DEVELOPMENT REVIEW BOARD

Planning - Case Comments

Project Number: PR-2022-006939

Project Name: American Gypsum

VERTICAL GRINDING / CALCINING MILL
OVERALL PLANT
CIVIL
SITE DEVELOPMENT PLAN

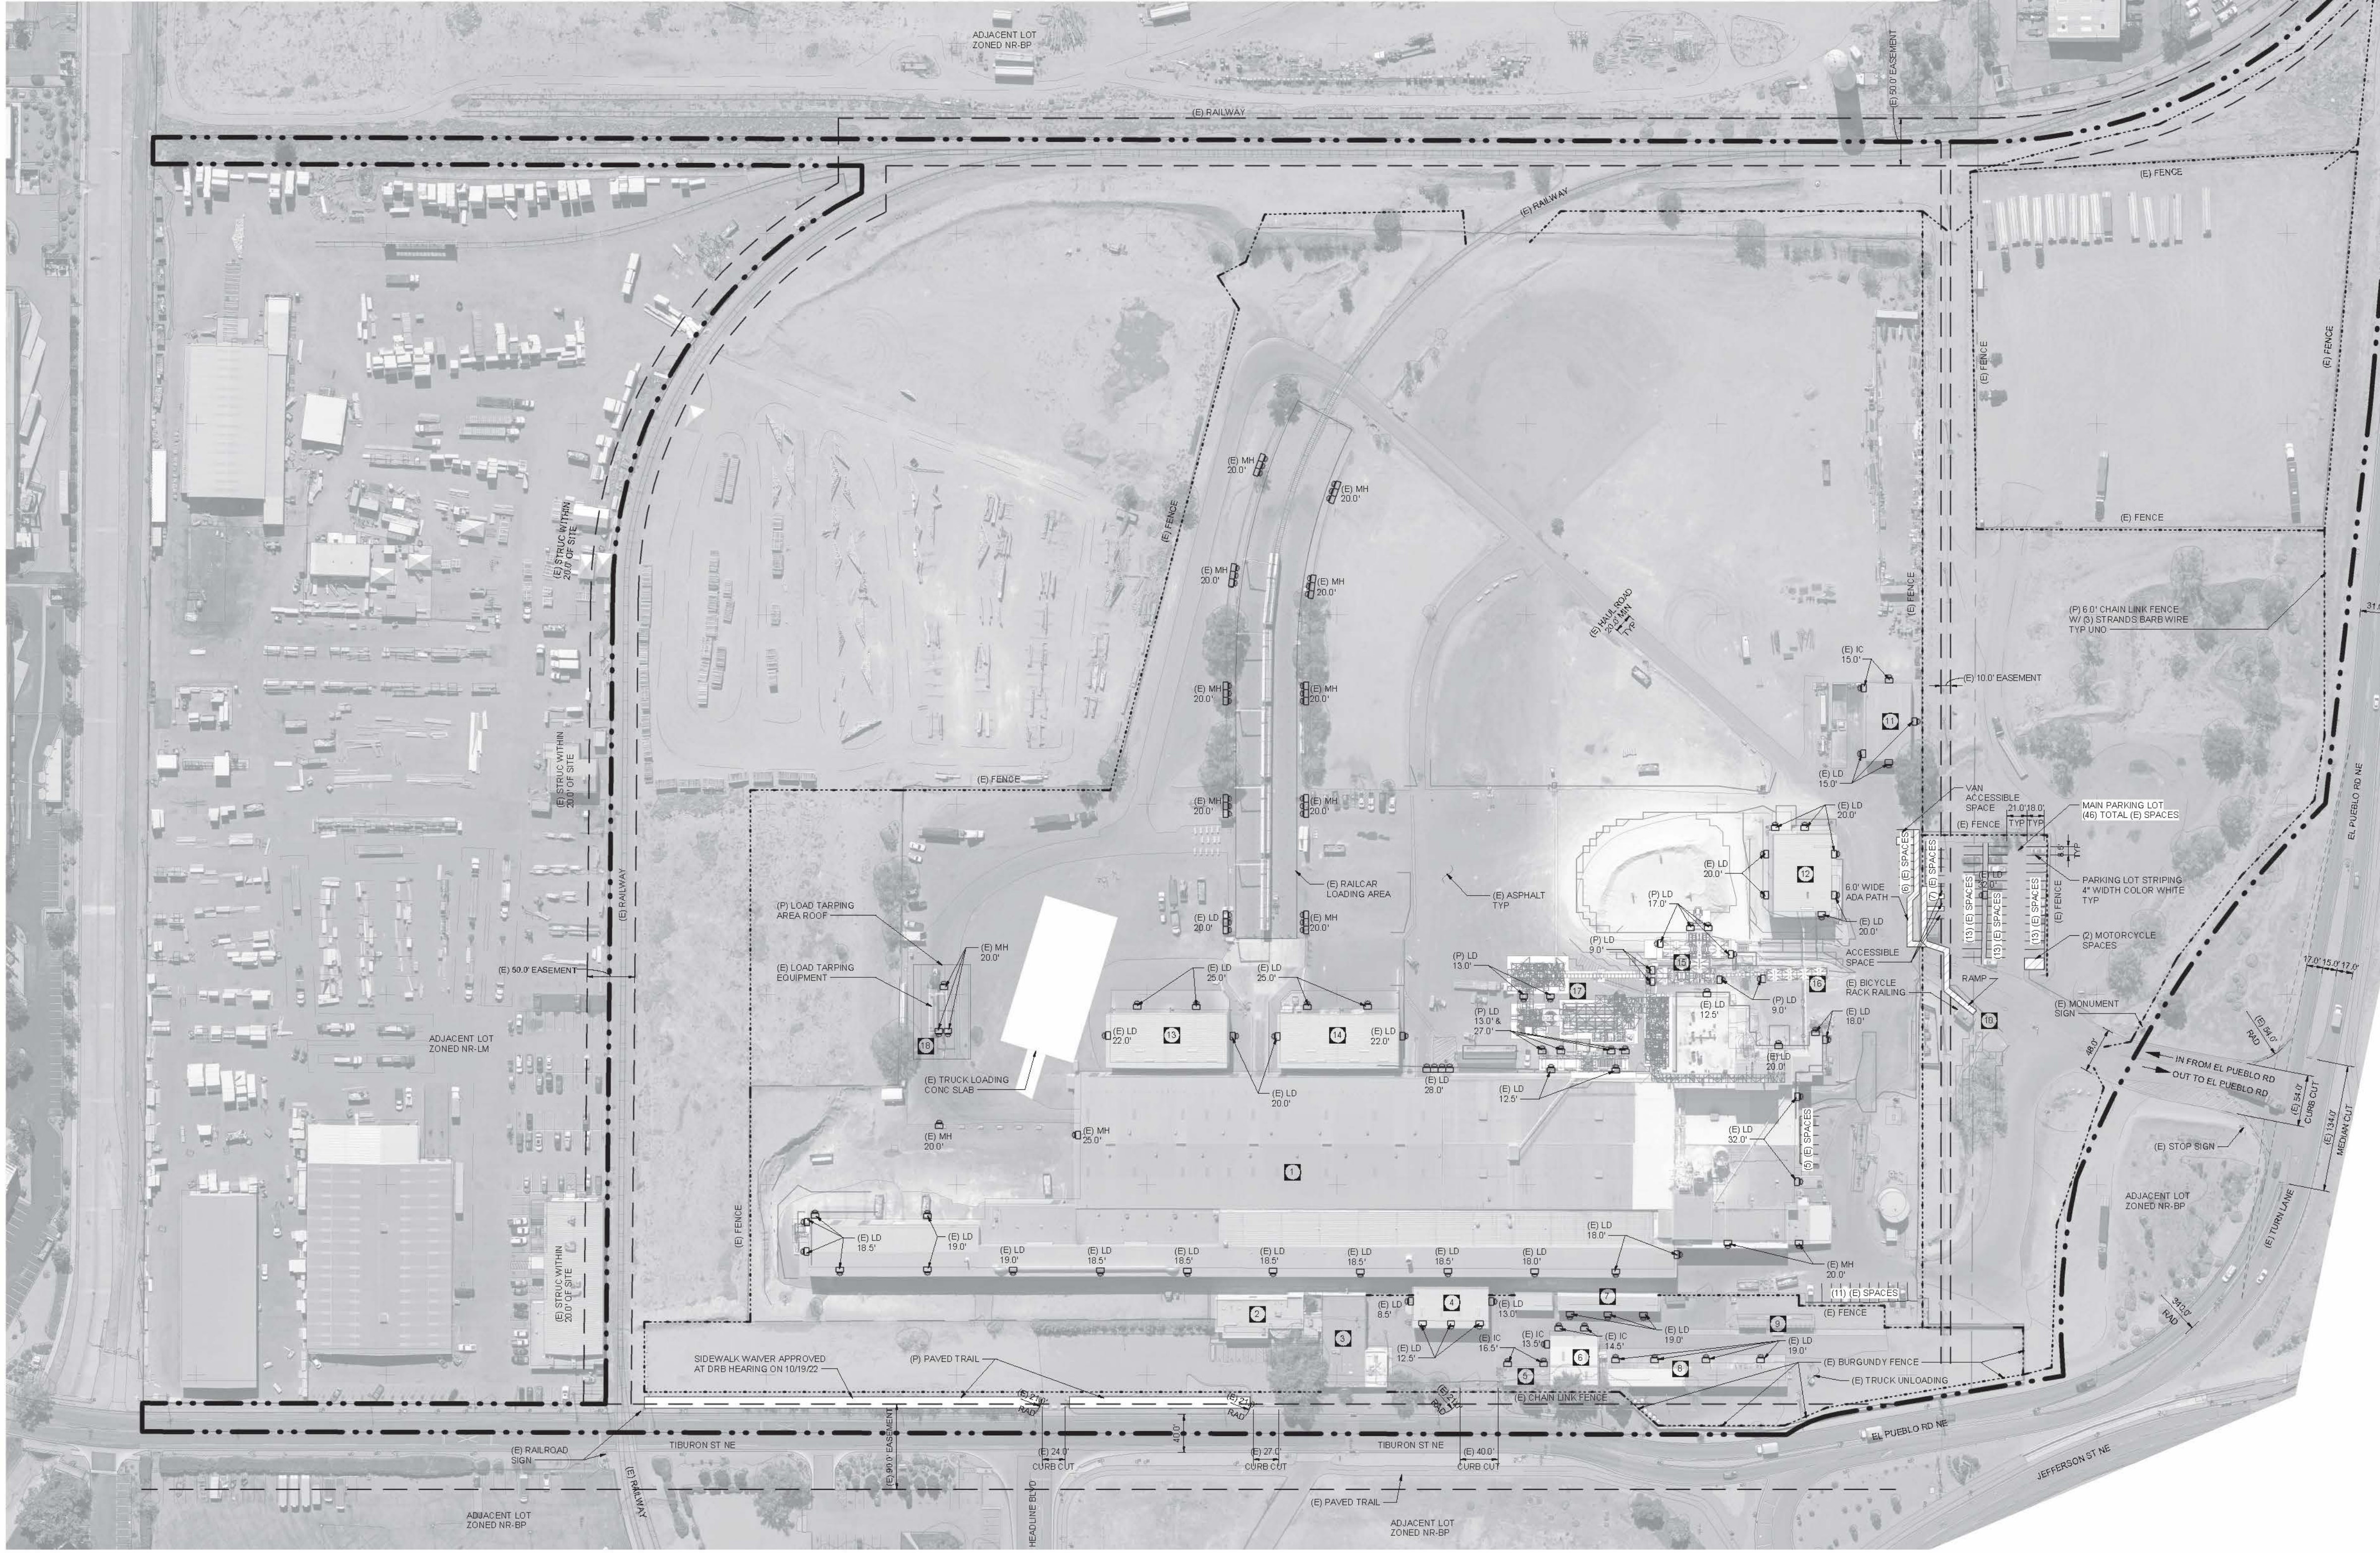
- The project and application numbers for the Site Plan Amendment must be added to the Site Plan Amendment. **The project application numbers have been added to the attached Site Plan. See attached updated drawing 1576-CC-121_2.**

- The signature blocks for the DRB signatures must be added to the Site Plan Amendment. Those signature blocks can be obtained at:
<https://documents.cabq.gov/planning/development-review-board/development-review-board-site-development-plan-signature-block.pdf>
The signature blocks have been added to the attached Site Plan. See attached updated drawing 1576-CC-121_2.

On the Overall Plant sheet of the Site Plan Amendment, under the Parking Criteria, it

shows that 69 parking spaces are provided while 143 parking spaces are required. Please explain how adequacy of parking is being determined. Please confirm that this modernization of the plant facility does or does not increase the employees and/or demand for parking on the site.

- On the Overall Plant sheet of the Site Plan Amendment, under the Parking Criteria, the motorcycle parking requirements of 5-5(D) of the IDO must be shown and be met. IDP shows 2 motorcycle spaces for required off street parking of 26-50 spaces. See attached updated drawing 1576-CC-121_2.

- Upon approval of the sidewalk waiver, a note identifying that Sidewalk Waiver and approval date by the DRB must be added to the Site Plan Amendment. This note has been updated to the attached Site Plan.

GFA on SDP is 233,696 SF / 5000 SF = 47 spaces. See attached updated drawing 1576-CC-121_2.
